land at, Piper Well Lane/Park
Head Lane, Birds Edge,
Huddersfield, HD8 8BADate: 13 March 2026
Our Ref: 2025/21120

Pre-application Enquiry for Residential Development at Land at, Piper Well Lane/Park Head Lane, Birds Edge, Huddersfield, HD8 8BA**1. Summary of your Proposal**

The pre application enquiry is seeking guidance in relation to the conversion of an existing vacant building into a residential use, relocation of the site access and erection of a detached garage.

15 Proposed Site Plan
1 : 500

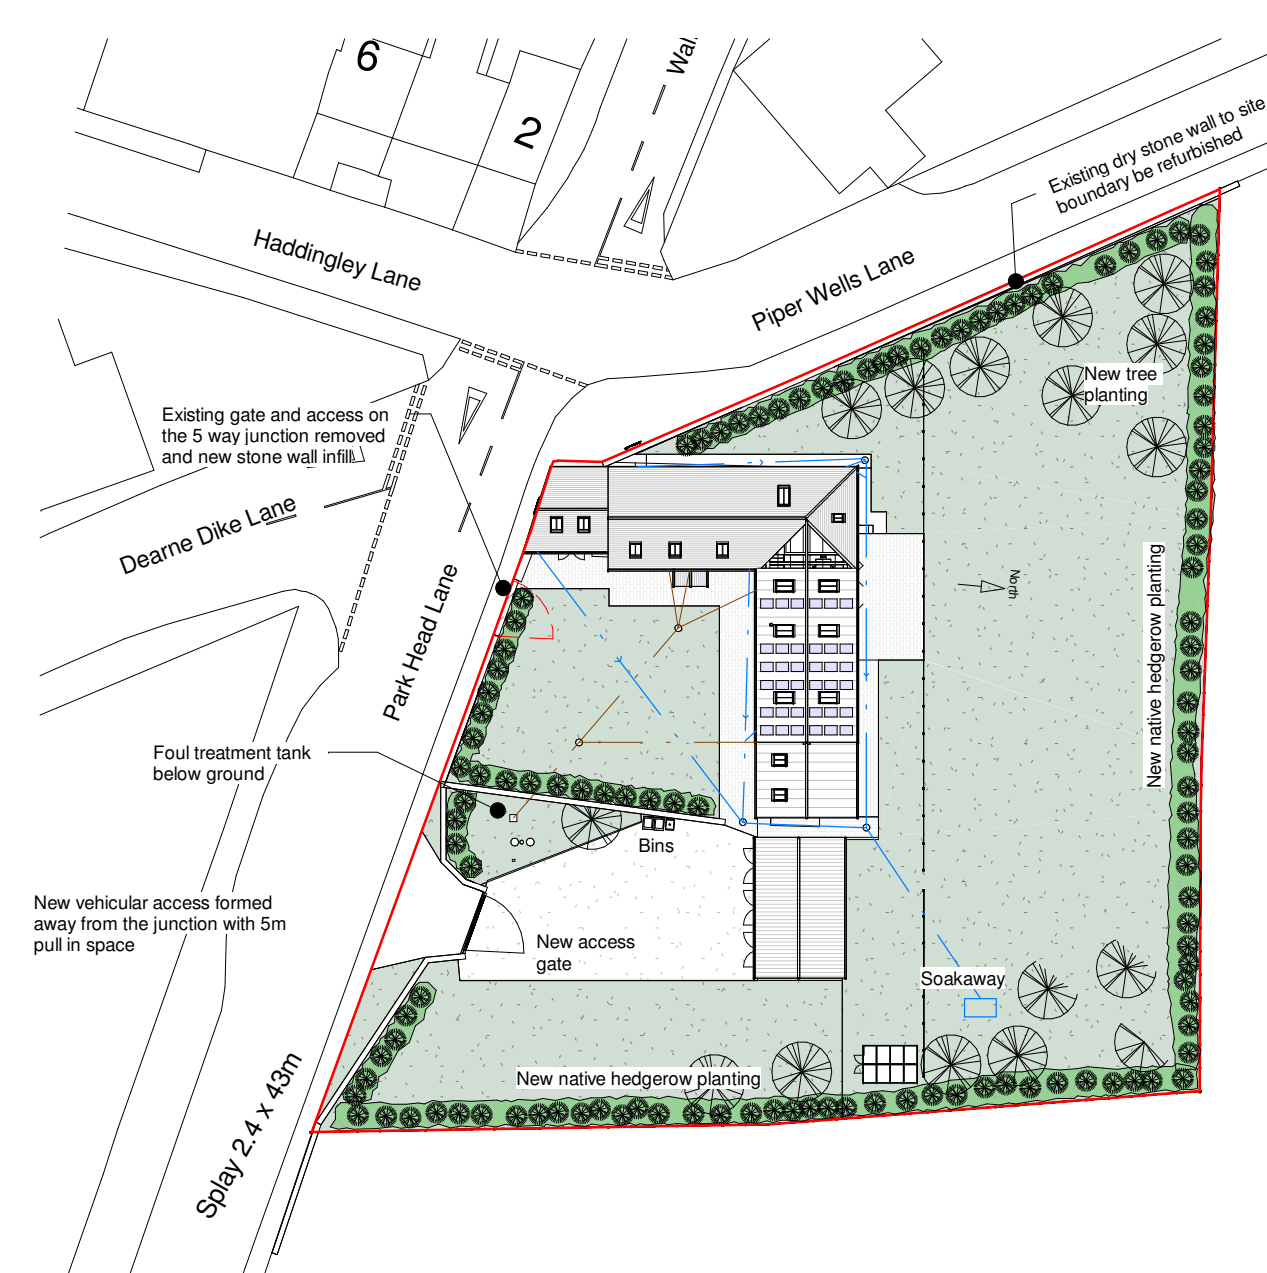
Applicant would need to ensure parking is to design standards and visibility splays would need to be provided based on The Design Manual for Roads and Bridges. To support this, speed surveys may be required up to 85th percentile. Details of bin storage and collection points would be required; new access gate would need to be set back 5m into the site and a swept path analysis would be required to be provided on final plans to ensure vehicles can exit and enter site in a forward gear.

Due to the size of the existing plot, a satisfactory layout which has sufficient amenity space, parking provision, safe access is likely to be possible on site. Therefore, the proposal would largely accord with Policy LP24 of the Kirklees Local Plan.

1 Proposed Garage Plan
1 : 50

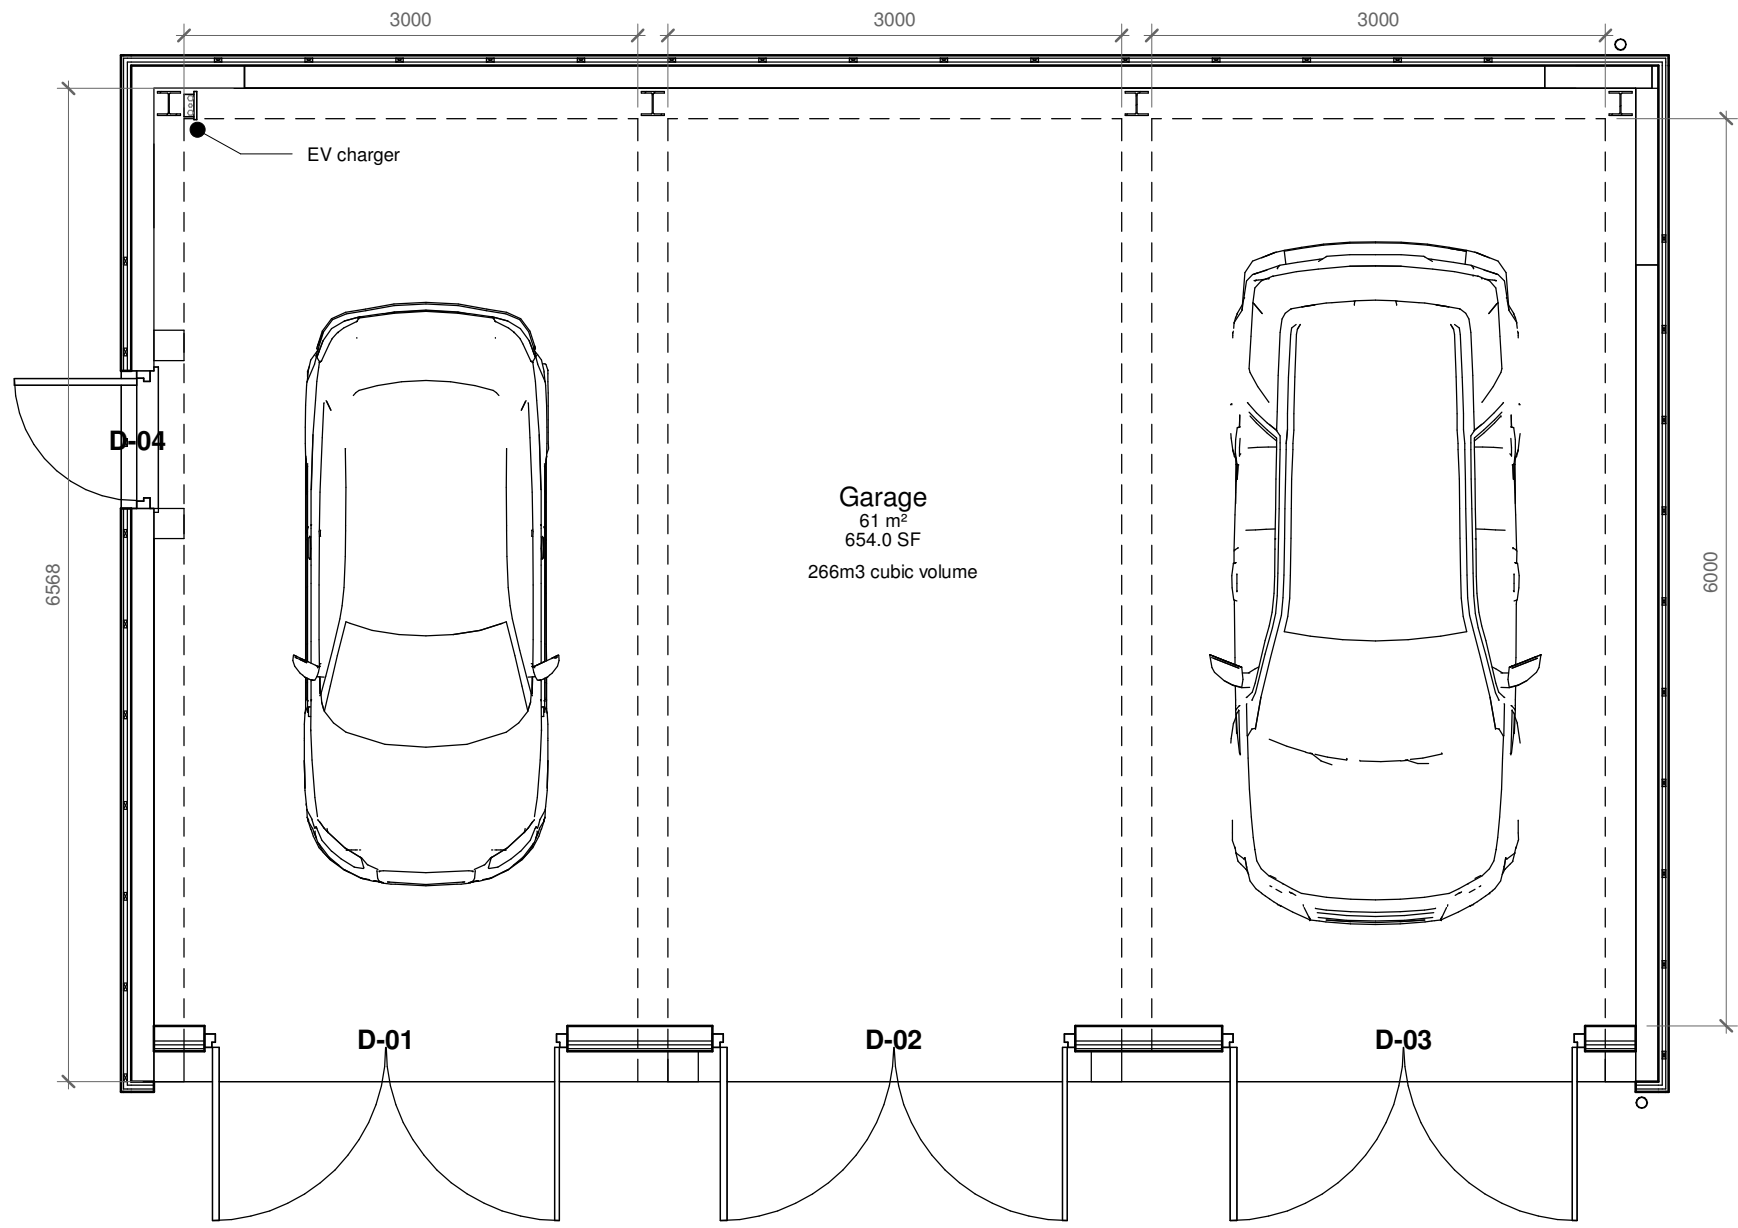
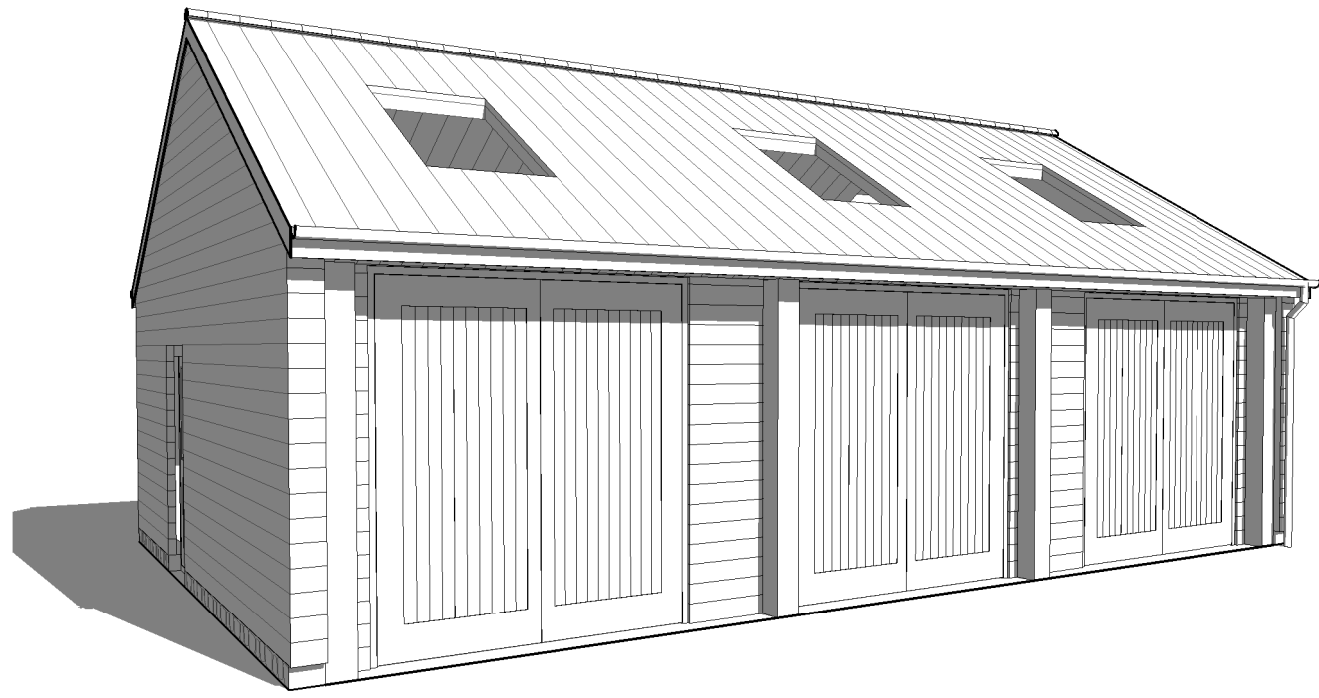
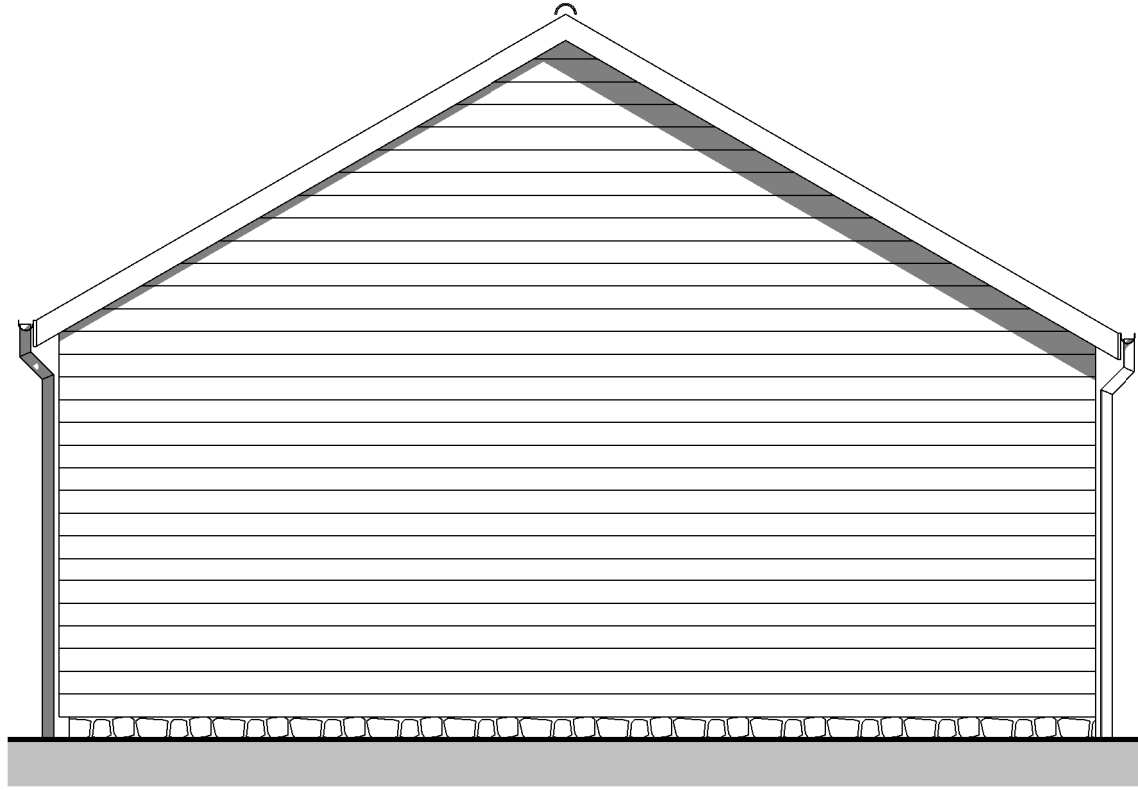
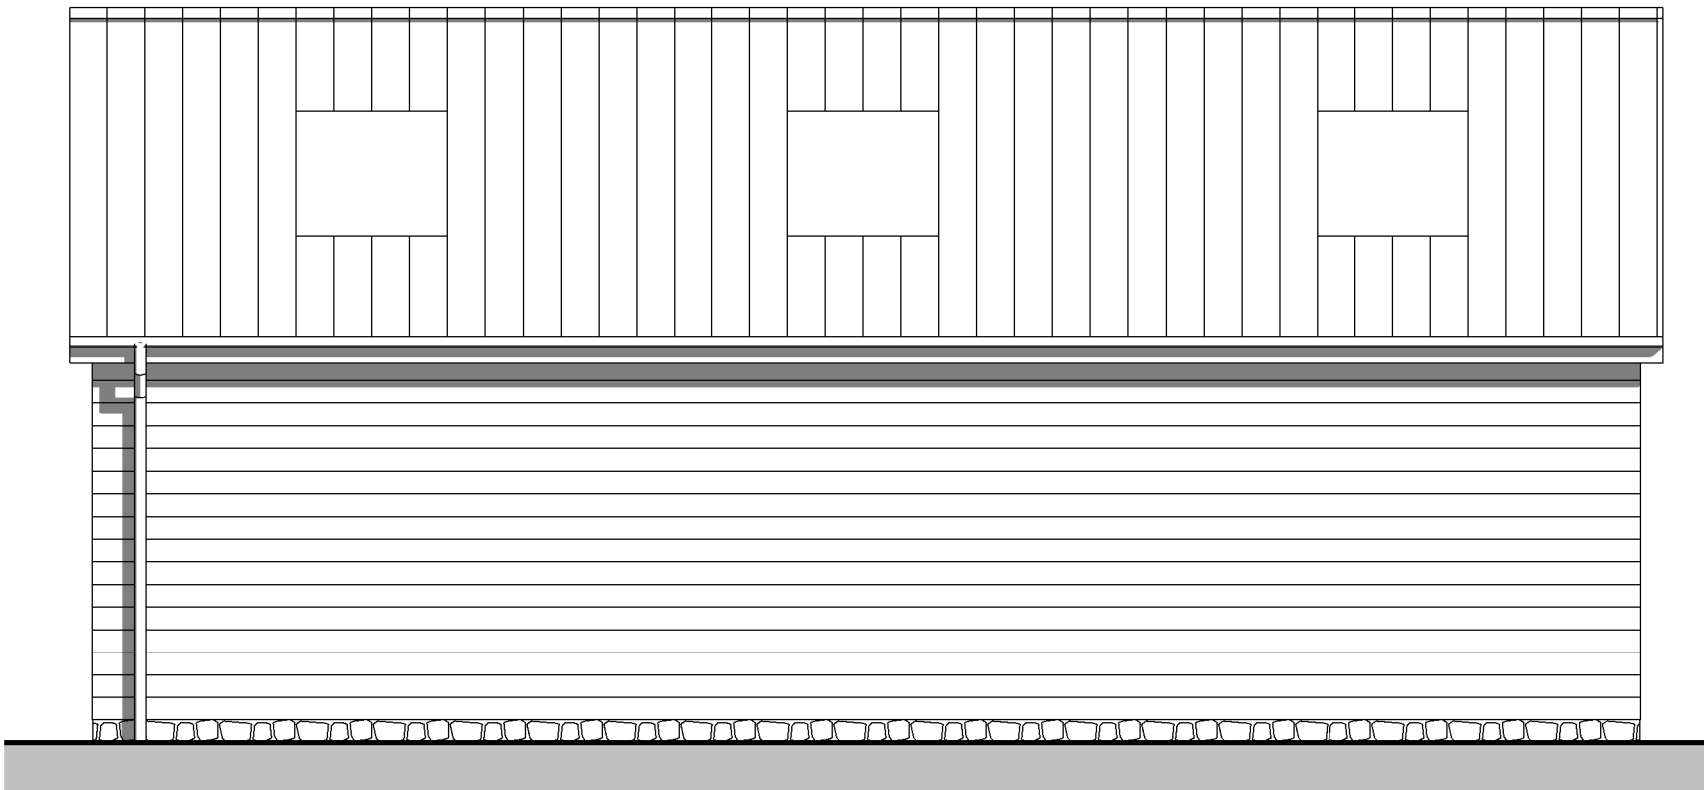
Officers do not consider that the proposed garage would be within the curtilage of the existing structure due to the location being outside of the main defensible boundary of the site.

The proposed garage building would constitute inappropriate development in the Green Belt. The development when coupled with its location, extending beyond the defined existing built form into open land would result in encroachment into open countryside, conflicting with Green Belt purpose (c) of Paragraph 143 of the NPPF. Under Paragraph 155(a) of the NPPF, development may be acceptable where it does not fundamentally undermine the purposes of the Green Belt; however, the proposal would erode a rural edge, lacking containment, and would undermine the Green Belt's function in this location.

However, the failure to satisfy 155(a) remains determinative, and the proposed garage is therefore contrary to Paragraph 155 of the NPPF and constitutes inappropriate development in the Green Belt.

No very special circumstances have been advanced by the applicant. In the absence of any such justification and given the identified harm to the Green Belt by reason of inappropriateness and encroachment into the countryside, the proposal remains contrary to paragraphs 153 and 155 of the NPPF. The relocation of the garage would be recommended should a full application be received.

In principle the design of the garage would be considered acceptable due to its materials and dimensions; however, as the proposed garage would be considered to represent encroachment into the green belt, it would be recommended that this is removed from the development or the garage is integrated into the host building.
